City of Albuquerque

RE: TRACT C, LOT 7 (F15/D30) AS-BUILT SUBMITTAL FOR CERTIFICATE OF
OCCUPANCY APPROVAL. ENGINEER'S CERTIFICATION DATED 3-4-99

RE: RE-PLAT TRACT C, LOT 7 (F15-D30). GRADING AND DRAINAGE PLAN FOR GRADING PERMIT APPROVAL. ENGINEER'S STAMP DATED JULY 6, 1998.

**SITE GRADING AND DRAINAGE PLAN**  
SCALE: 1" = 20'

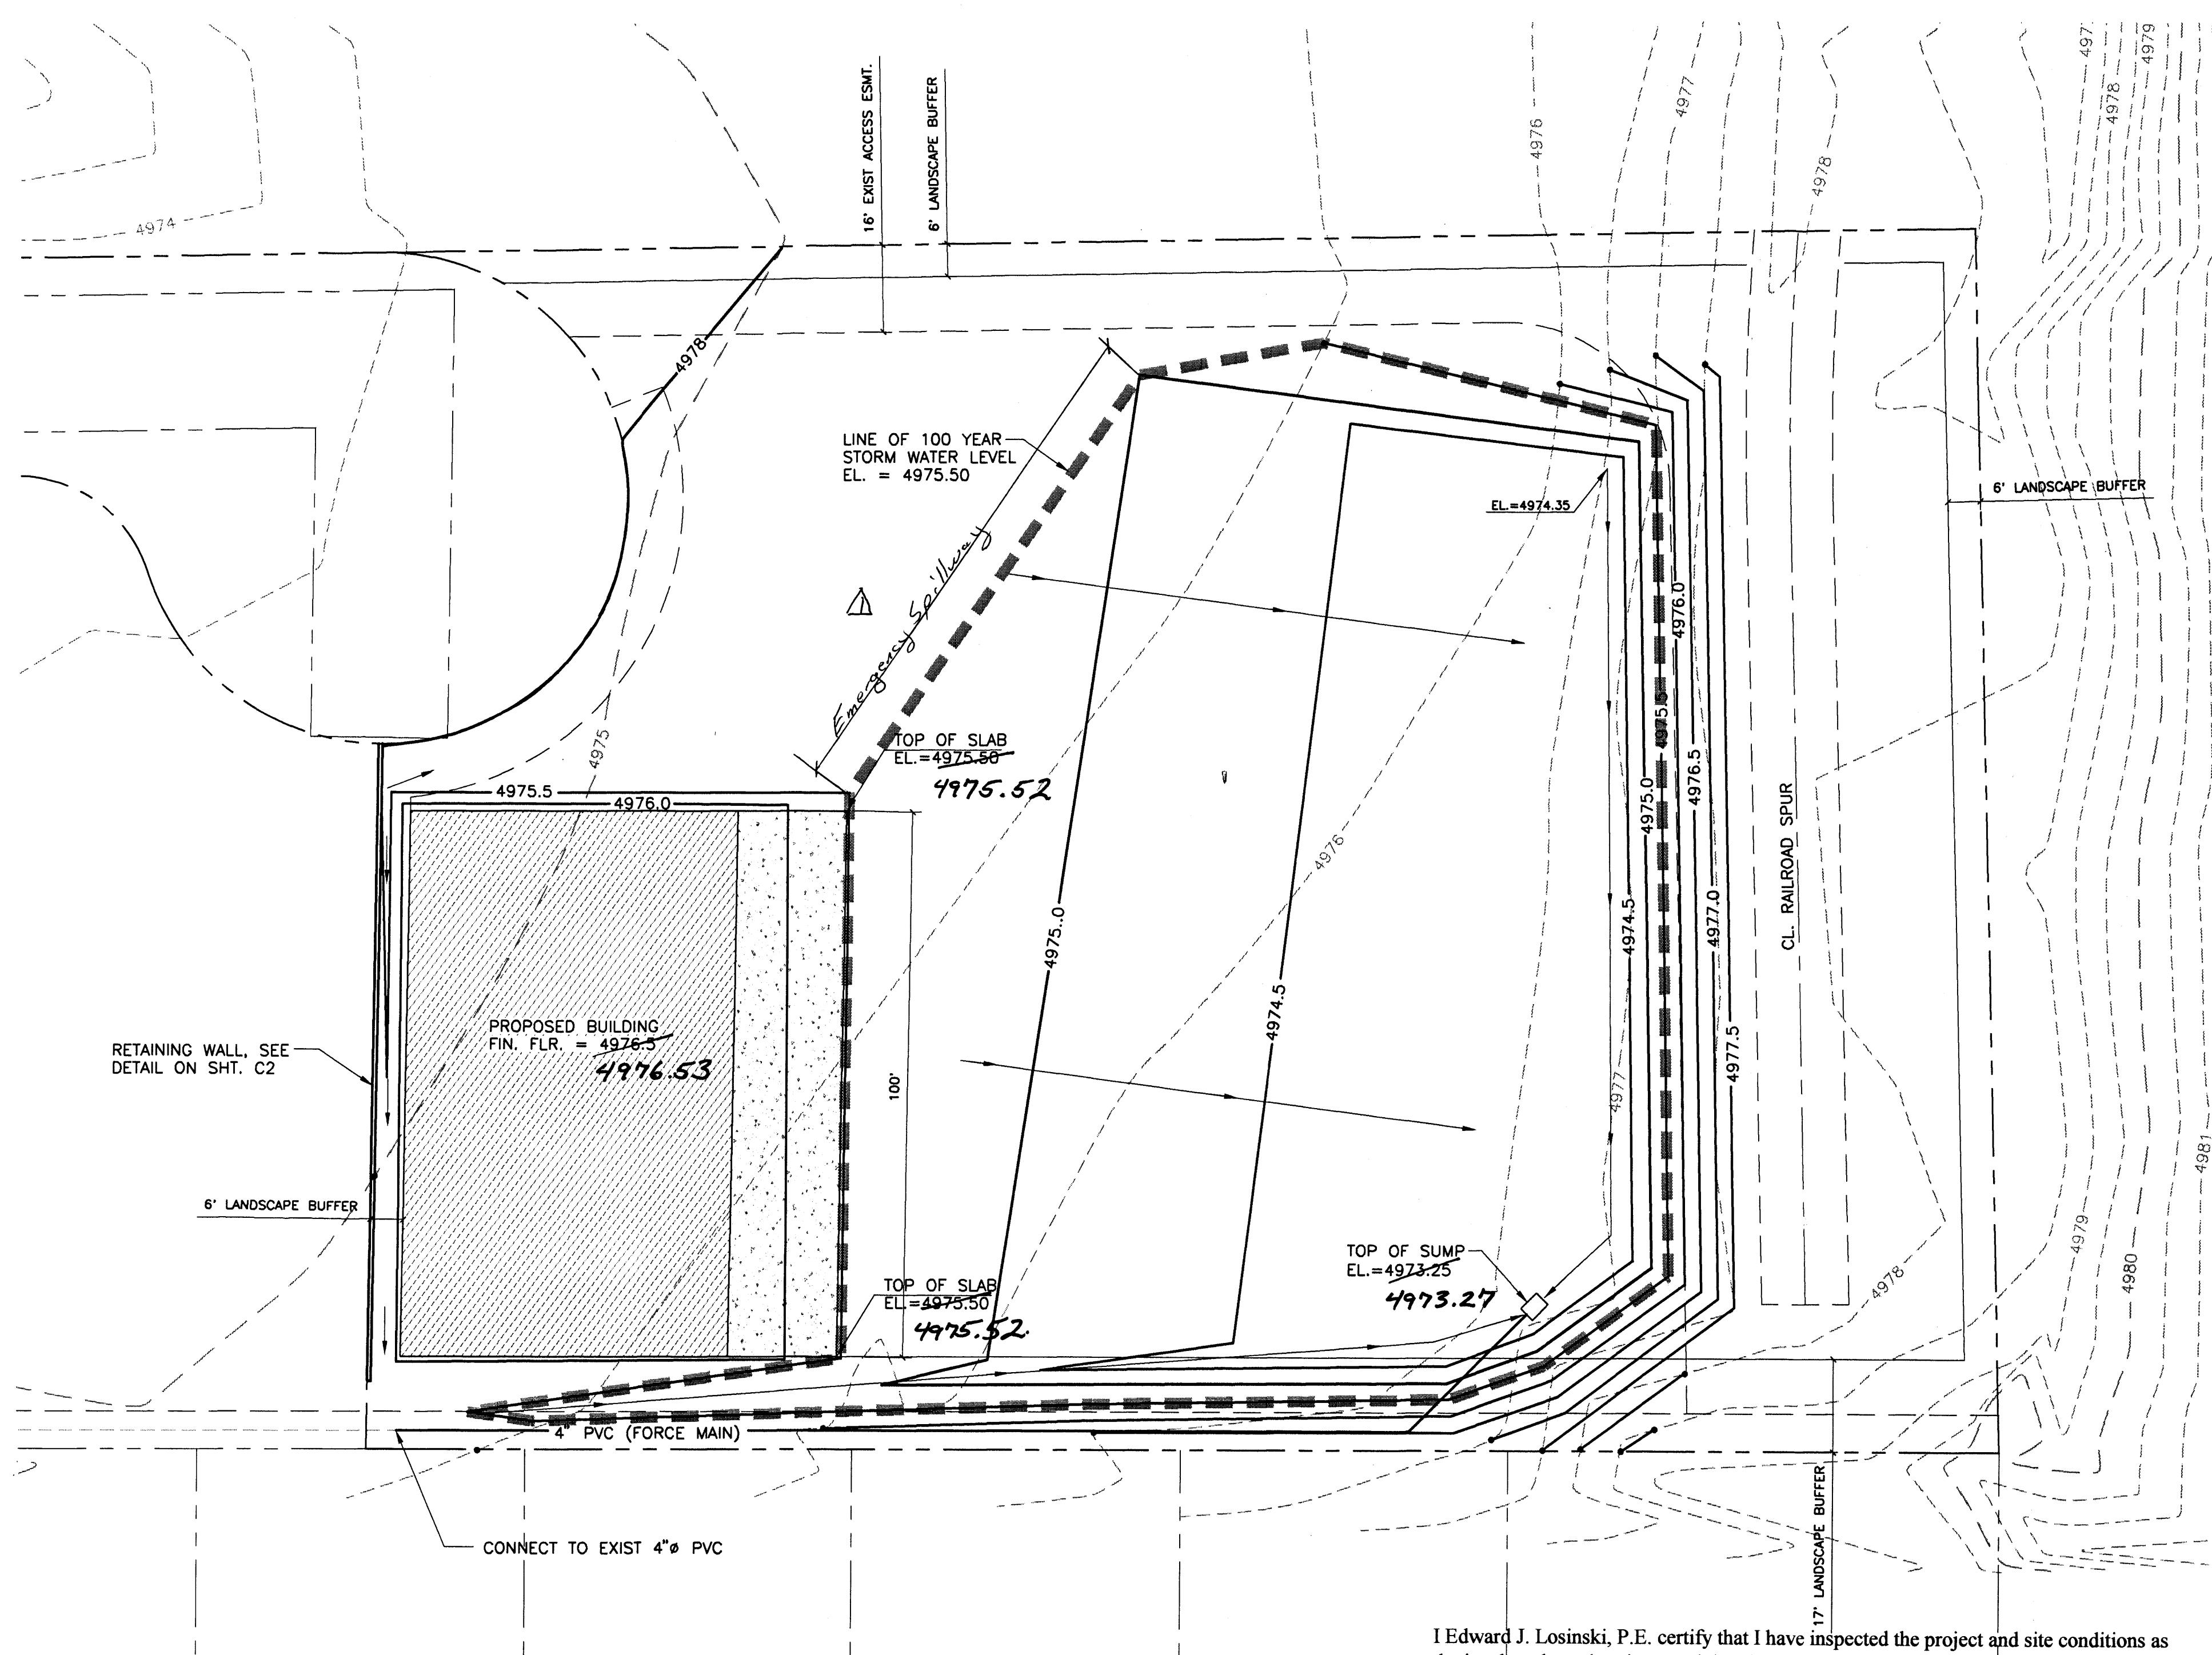
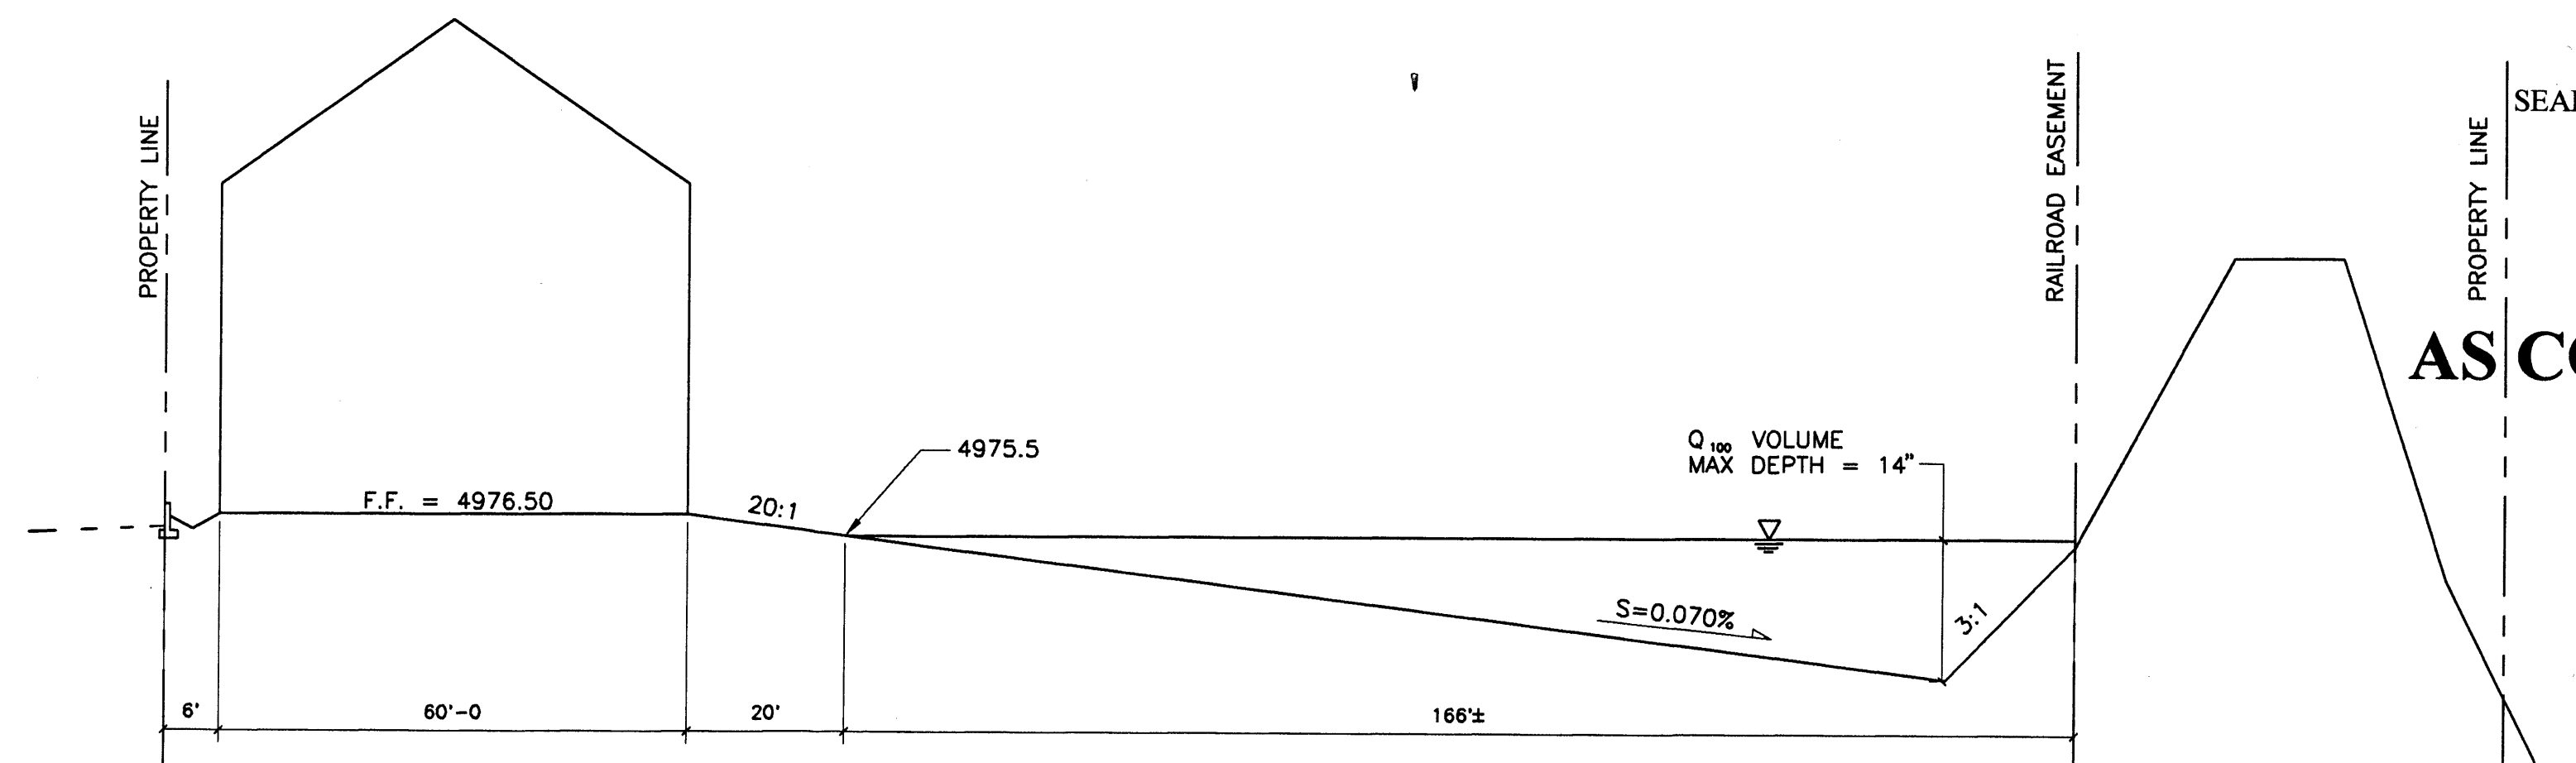
As shown on the profile, the 6-foot landscape buffer and west half of the roof will contribute to cross lot drainage onto Lot 6 (which would require a drainage easement). The swale to the south indicates that you intend to bring both to the pond. Clearly show/state that roof drains and buffer strip do so.

The profile has a mixed scale. Use same scale as plan. Show 100-yr water surface elevation on plan. Provide for an emergency spillway from pond. Label 4-inch line as force main.

Show sump pump installation. Water will be left standing in the sump itself.
